Date 30 October 2023
Our Ref 23/01068/FUL

Town and Country Planning Act 1990 (As Amended)
135 Riverview Road, Ewell, Surrey

Conversion and extension of existing garage granted under 20/00589, to a one bed studio bungalow, in the rear garden of 135 Riverview road, whilst leaving a parking bay for 135a, as required under planning permission 20/00589

PROJECT: 135B, Riverview Road, Epsom KT19 OJR CLIENT: Mr R O'Sullivan  
TITLE: Proposed ground floor plan of studio in relation to 135  
SCALE: 1:100 on A3 DWG NO: 682B/PL/110 REV: G

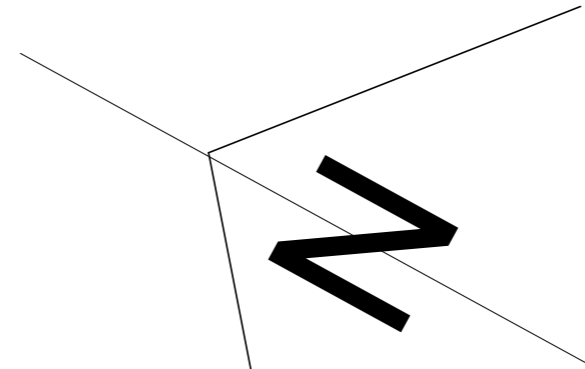
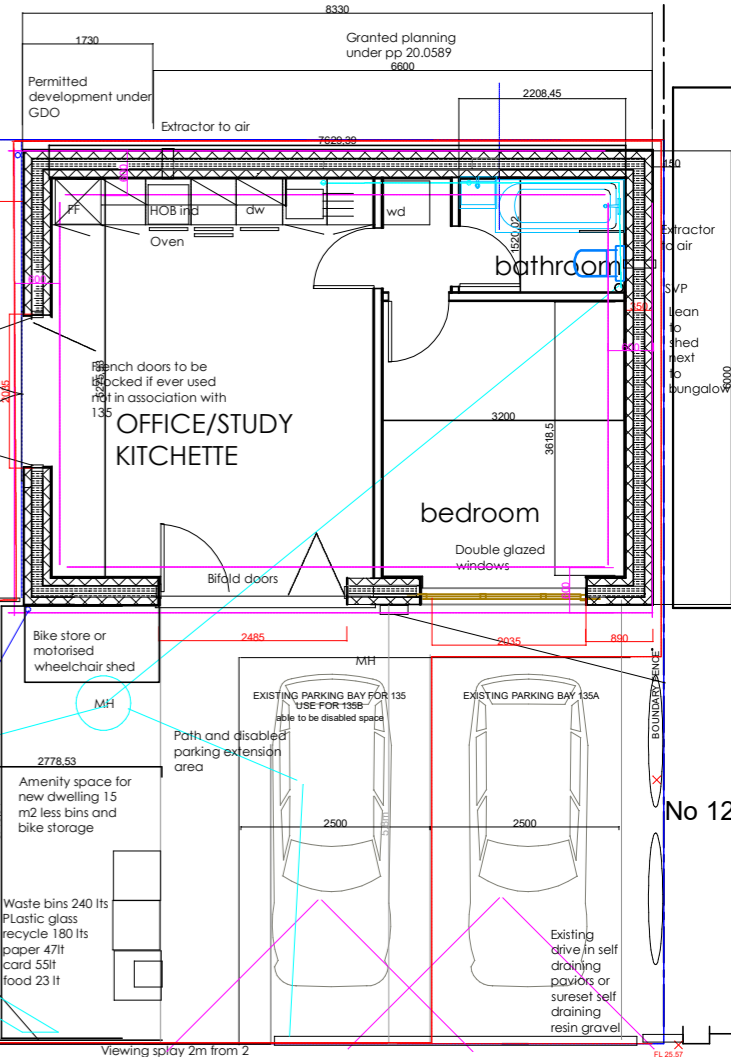
2 Please provide a Waste Bin and Recycling Plan especially one detailing the location of these items for No. 135.

ALEX IMLACH DESIGN 02088779955
 PROJECT: 135B, Riverview Road, Epsom KT19 OJR CLIENT : Mr R O'Sullivan
 TITLE : Proposed ground floor plan of studio in relation to 135
 SCALE: 1:100 on A3 DWG NO: 682B/PL/110 REV: D

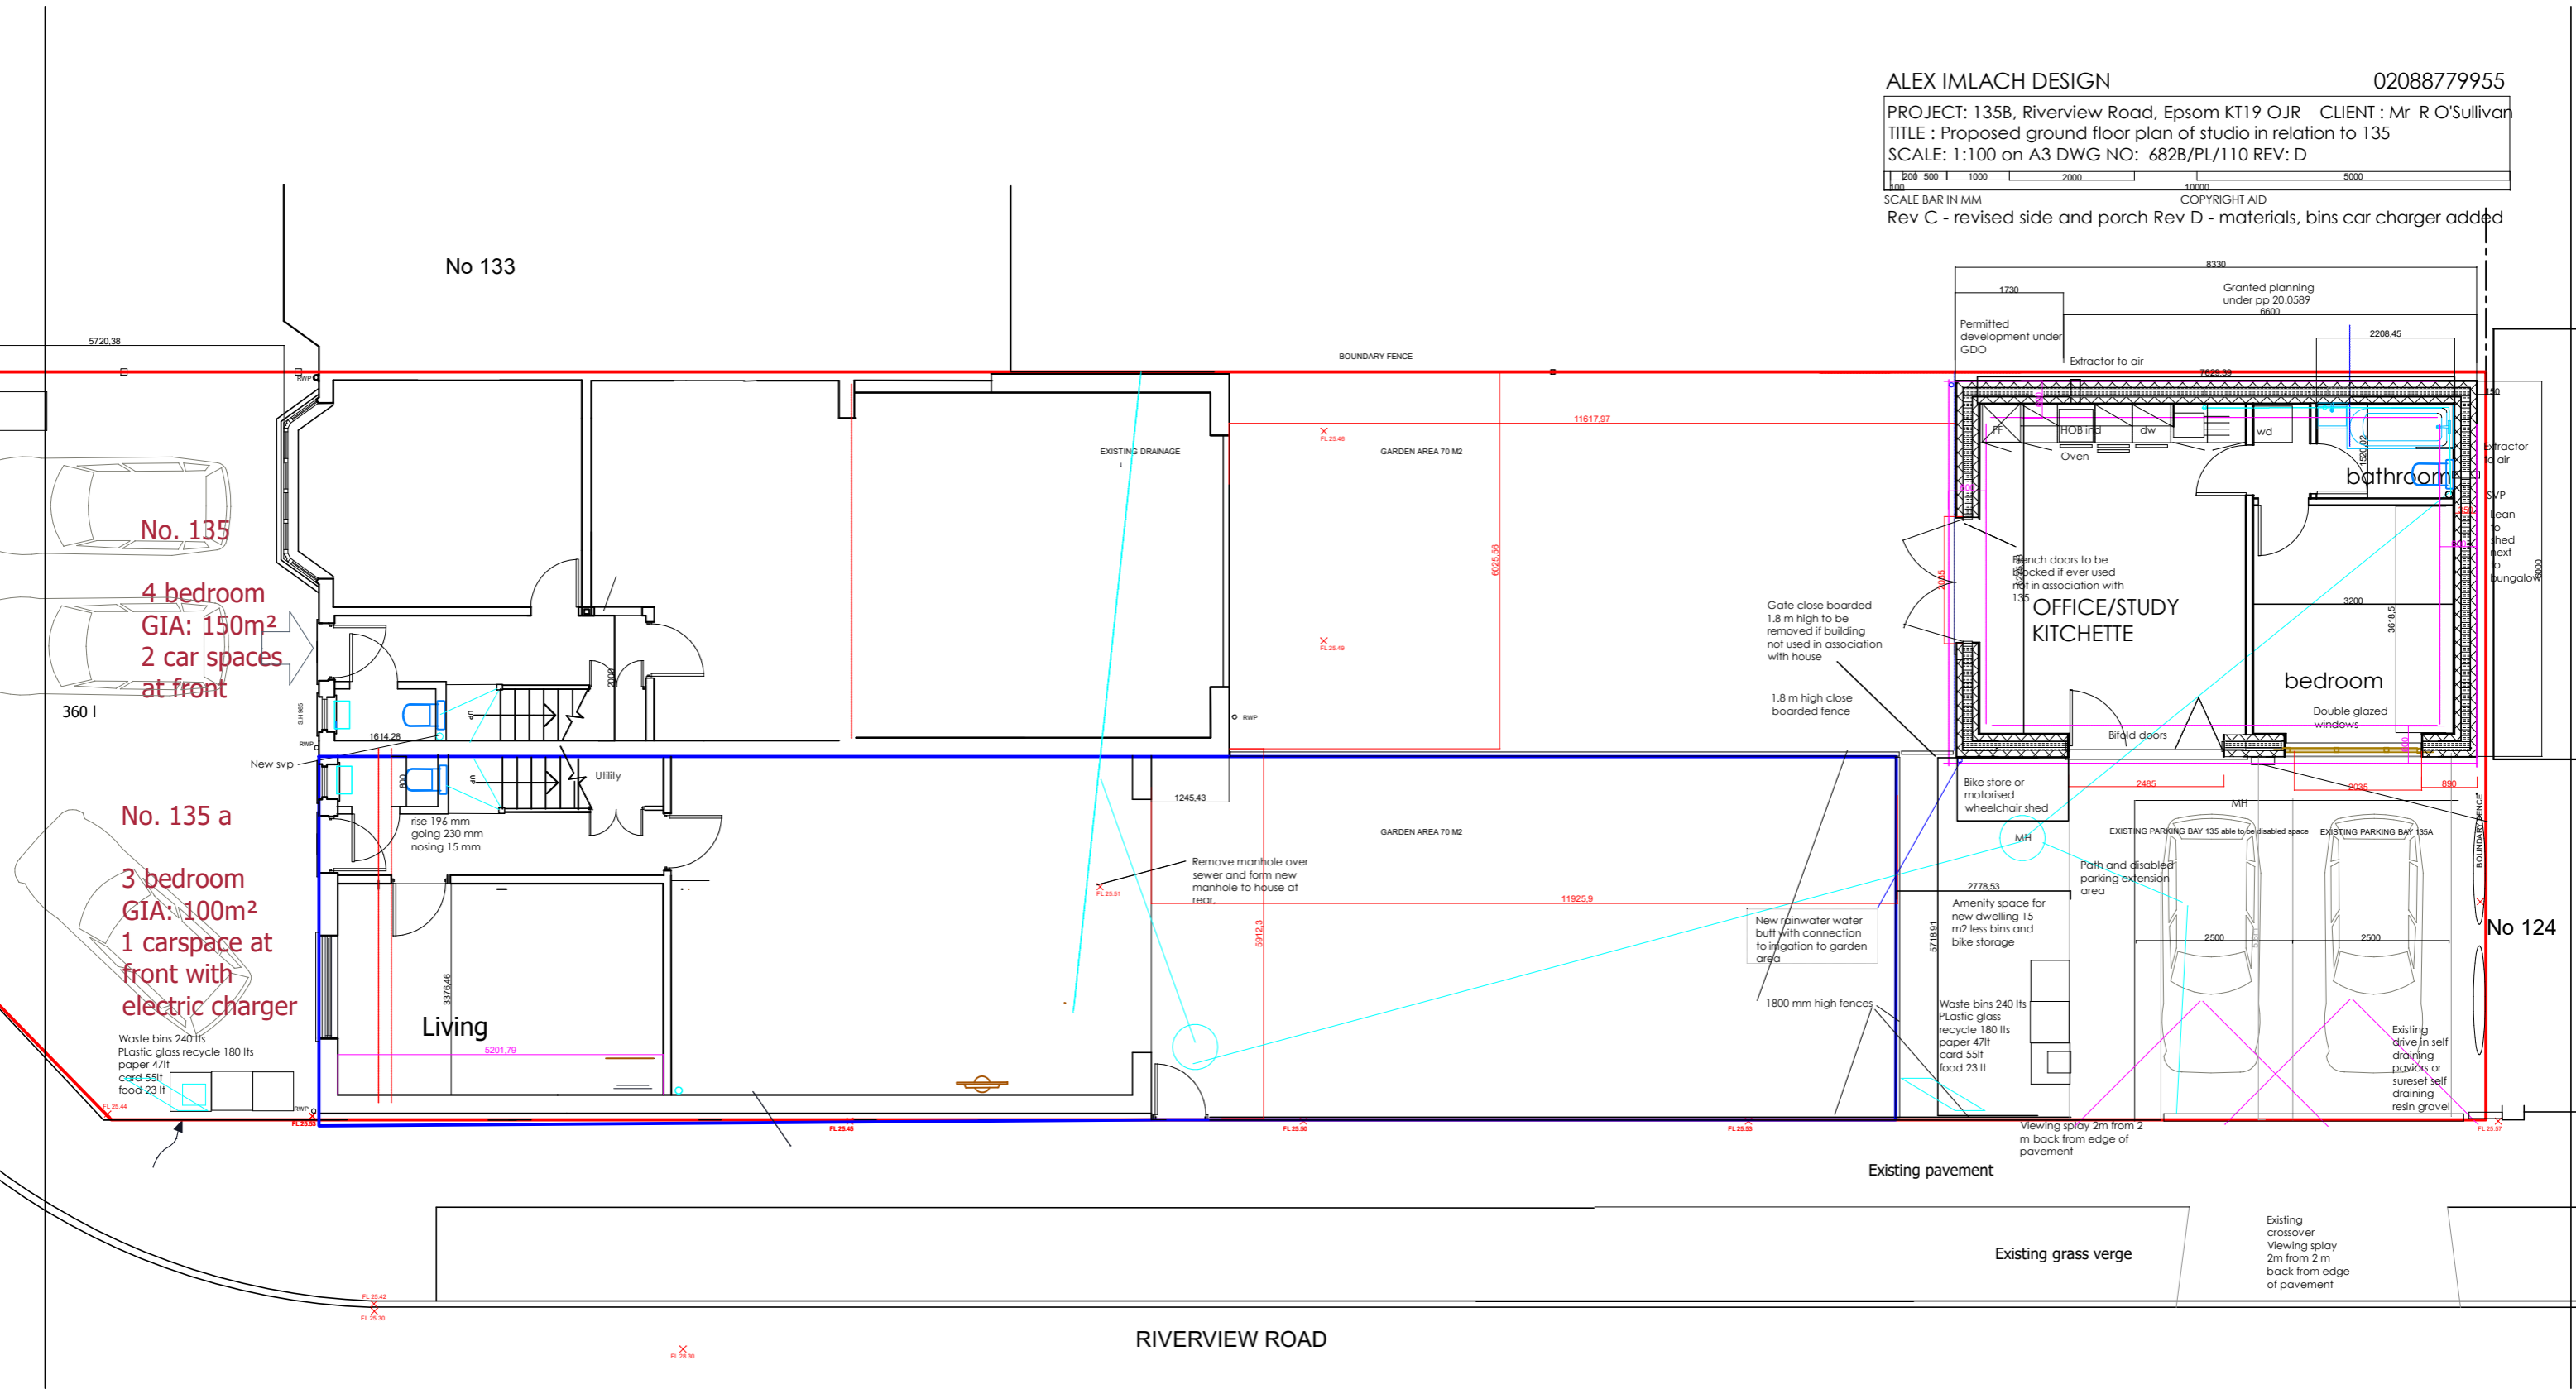
1 Incorrect Site Location Plan. This is a plan identifying the exact location of the application site, which must:- include a title stating the address of the site- include the direction of North- the red line is incorrect - it must also include the access to the highway as shown on drawing no.682B/PL/110 Rev:D. - you will also need to sign Certificate of Ownership B and serve notice to SCC Highways.
